January 9, 2024

**Re: Sage Plaza Storage
Erosion and Sediment Control Plan
Engineer's Stamp Date 1/4/24 (M09E012B)**

Based upon the information provided in your submittal received 1/5/2024, the above-referenced ESC Plan cannot be approved for Grading Permit or Building Permit until the following comments are addressed.

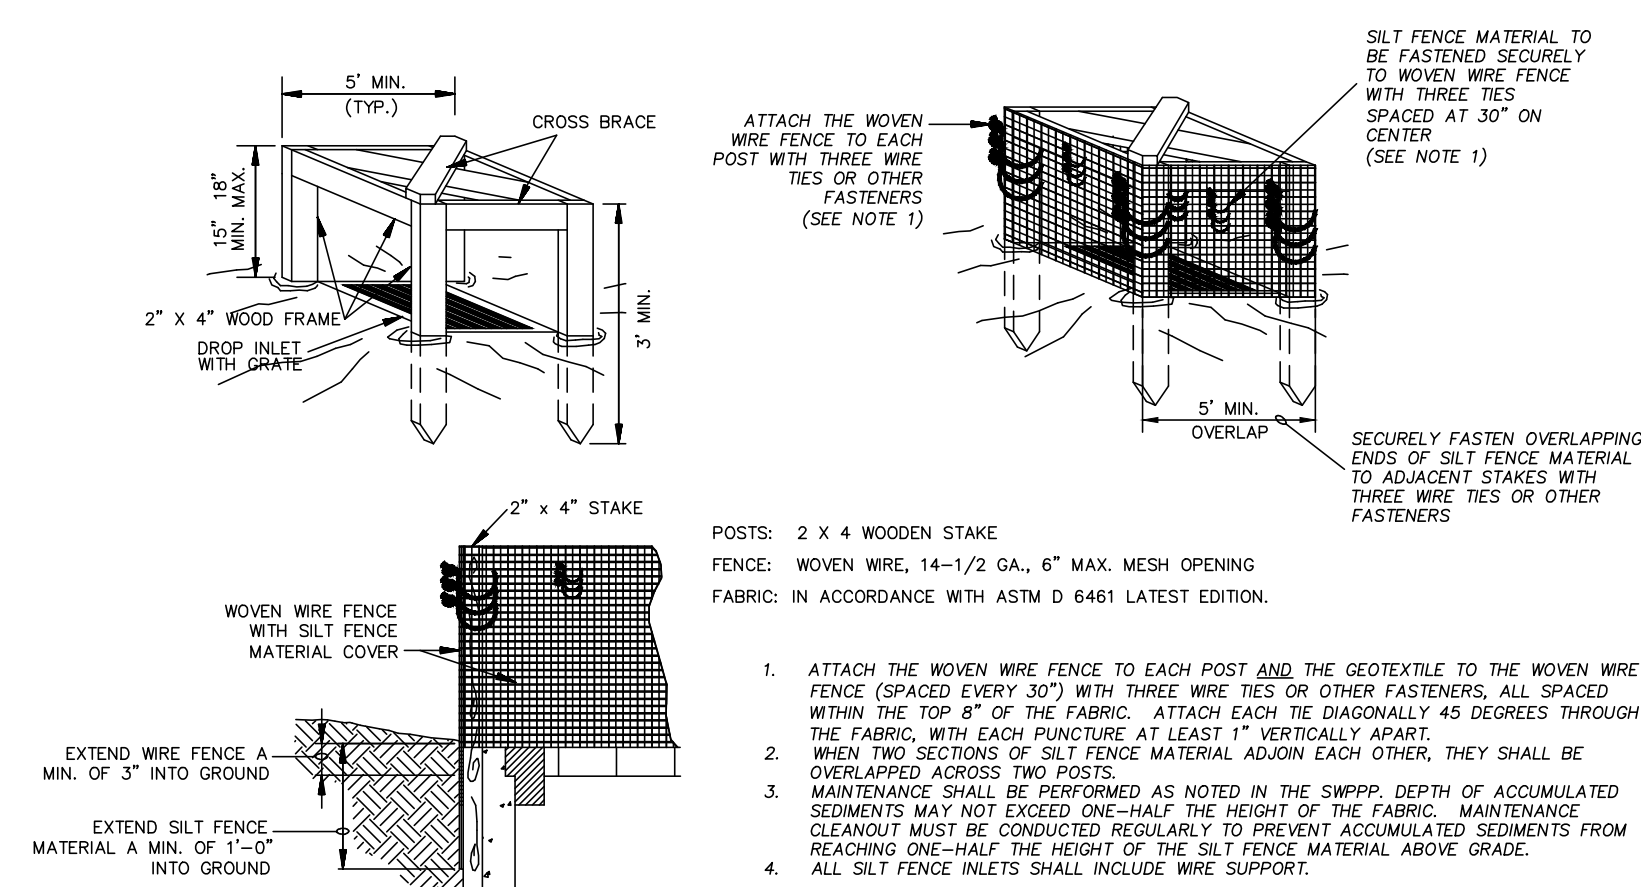
5. Provide calculations for the Sediment Trap design showing compliance with CGP Part 2.2.12.c which requires storage for either:
 - a. The calculated volume of runoff from a 2-year, 24-hour storm; or

- b. 3,600 cubic feet per acre drained.

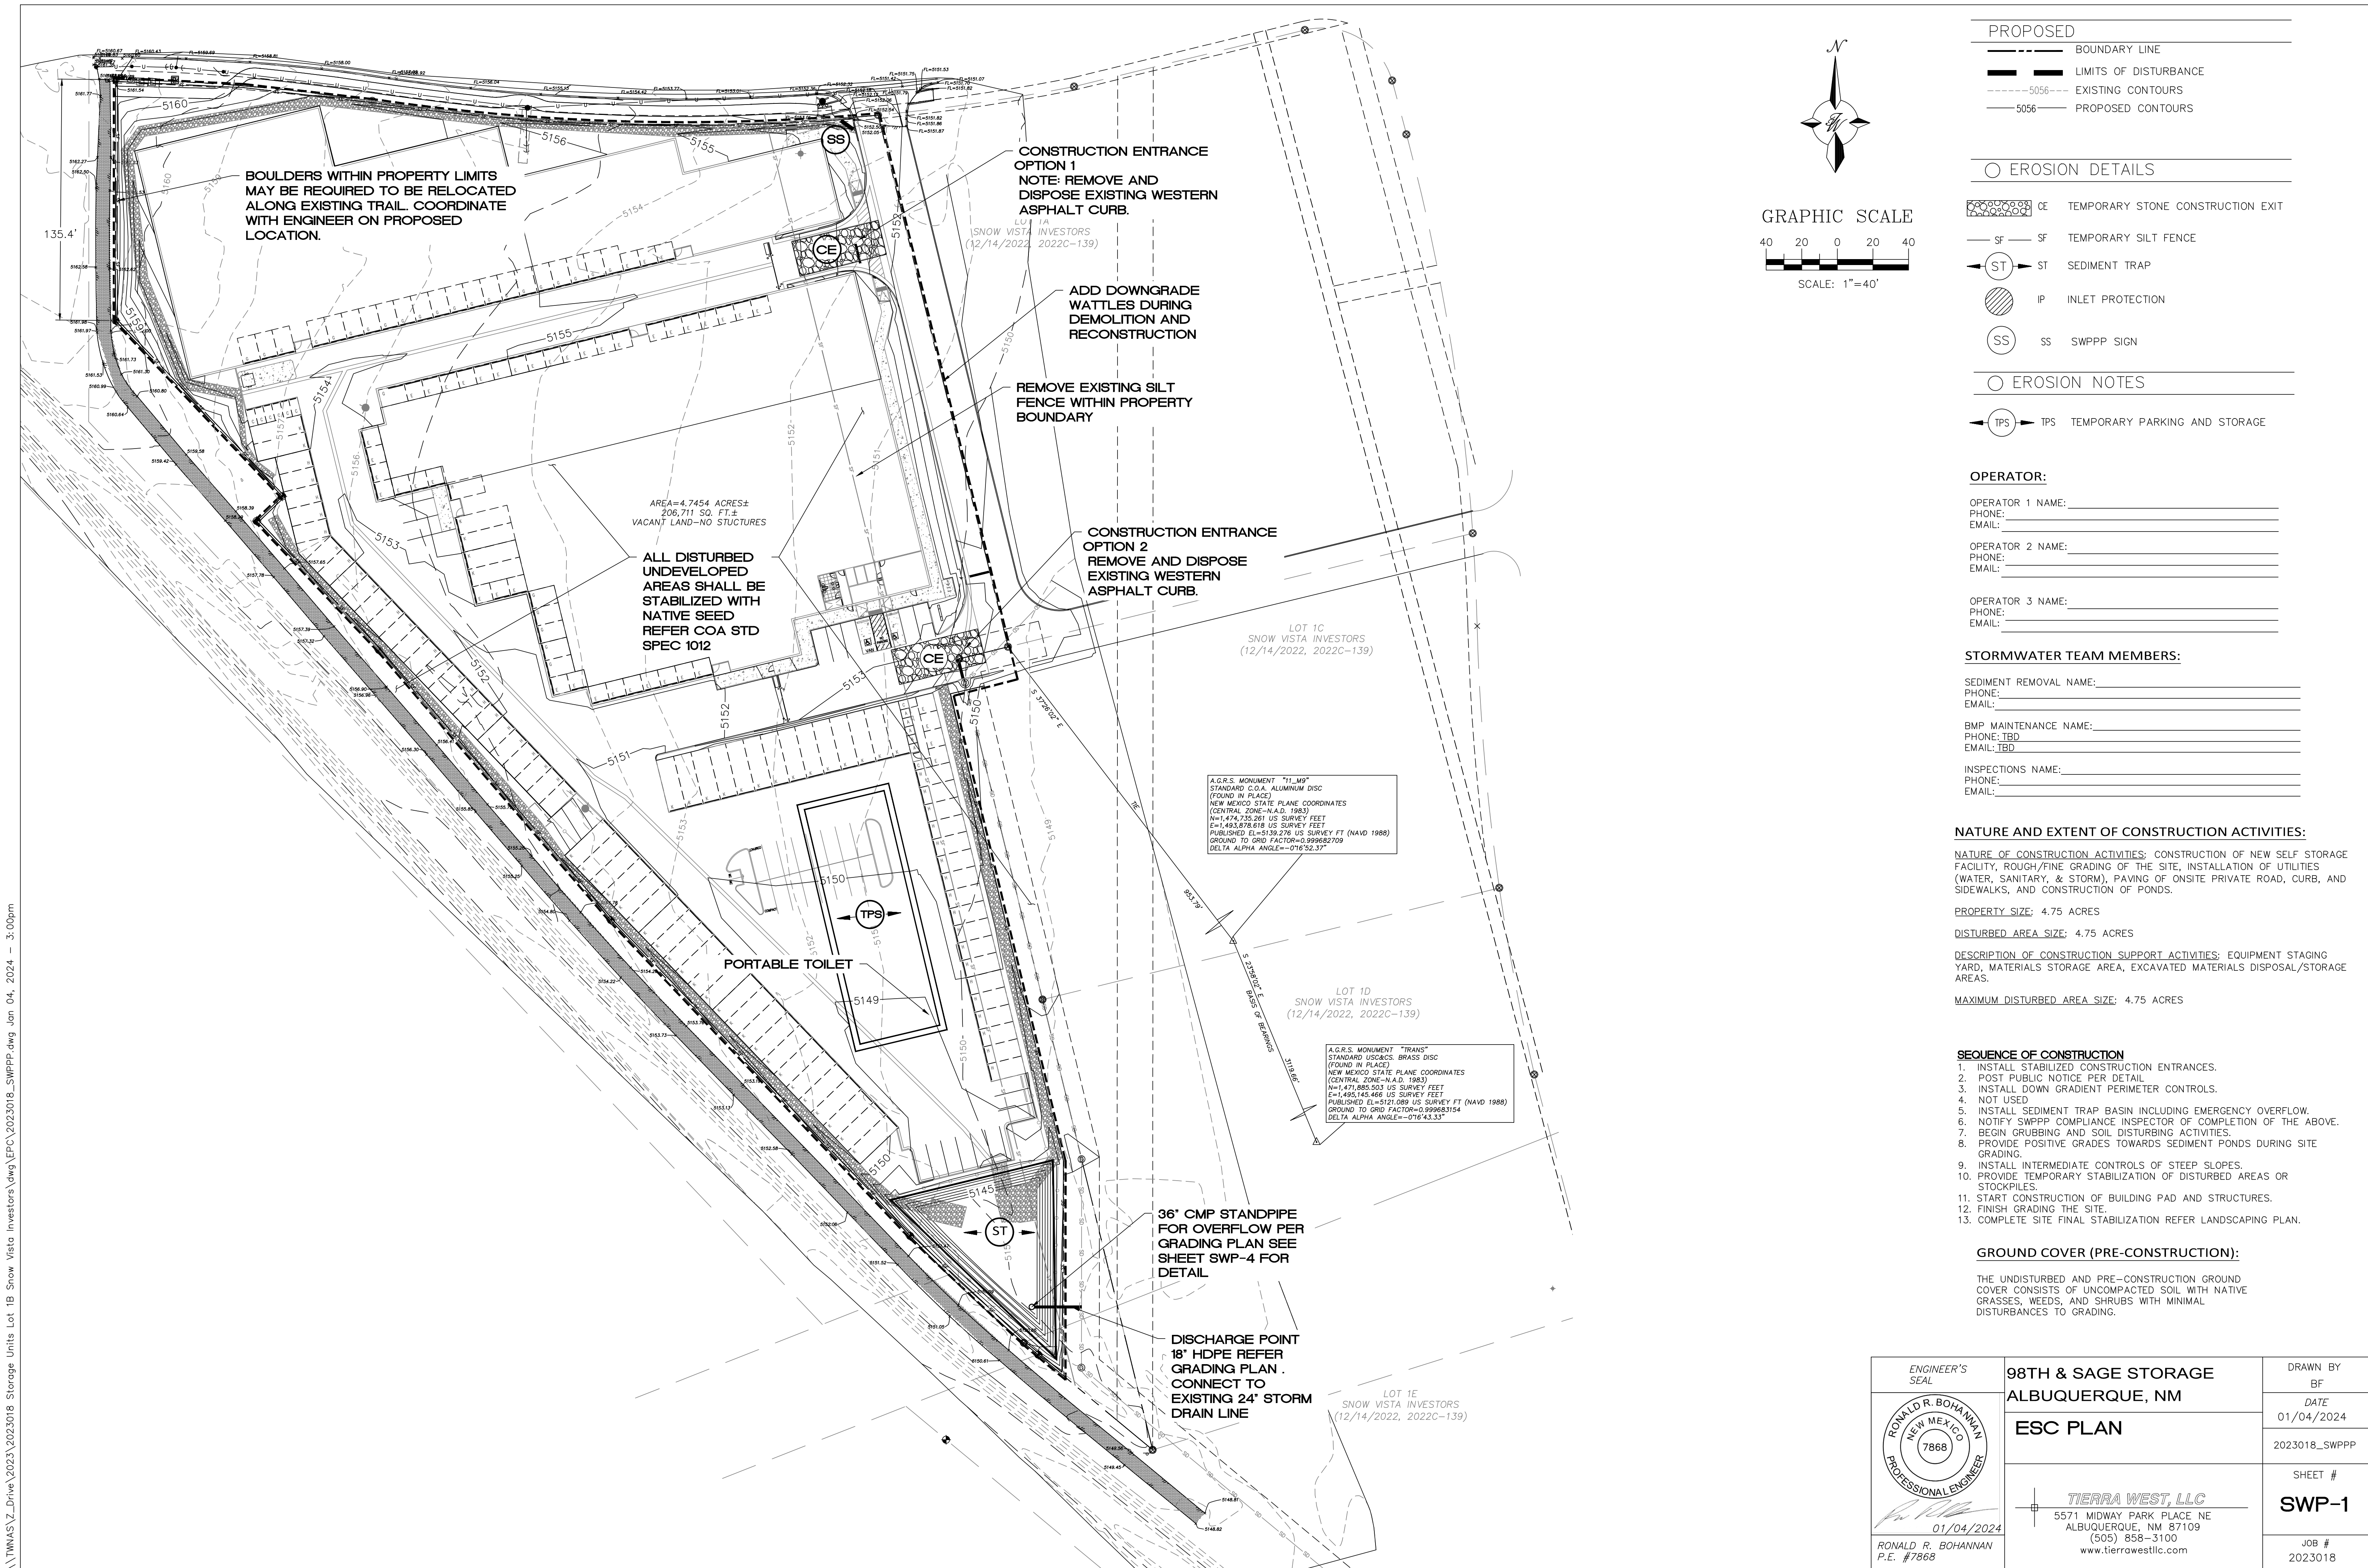
3. The ESC Plan can't be approved until after Hydrology approves the G&D Plan for each specific purpose, Site Plan, Grading, Building Permit, and Work Order. The only purpose Hydrology has approved so far is Site Plan. The existing and proposed grades must be shown on the ESC Plan, and they must agree with the Grading Plan approved by Hydrology (CGP7.2.4.b.ii);

4. The SWPPP must include site-specific interim and permanent stabilization per CGP 9.6.1.c.i. Provide a specification on the ESC Plan along with schedules for implementation per CGP 2.2.14. Label areas where existing vegetation is to be preserved and not graded at this time. Label areas to be stabilized with landscape rock (all areas in the public ROW) and show typical section and specifications. Label areas to be stabilized with vegetation and provide details and specifications.

6. Provide details, including specifications for construction, inspection, and maintenance of erosion controls and velocity dissipation devices to prevent erosion at inlets and outlets of the sediment traps per CGP Parts 2.2.12.e and 9.6.1.c.i.
7. Vicinity map – add a zone atlas map clearly indicating location and street names.
8. The City Standard ESC Notes are outdated. Please use the current City Standard ESC Notes attached.
9. Update the engineer's stamp date each time the plan is changed.
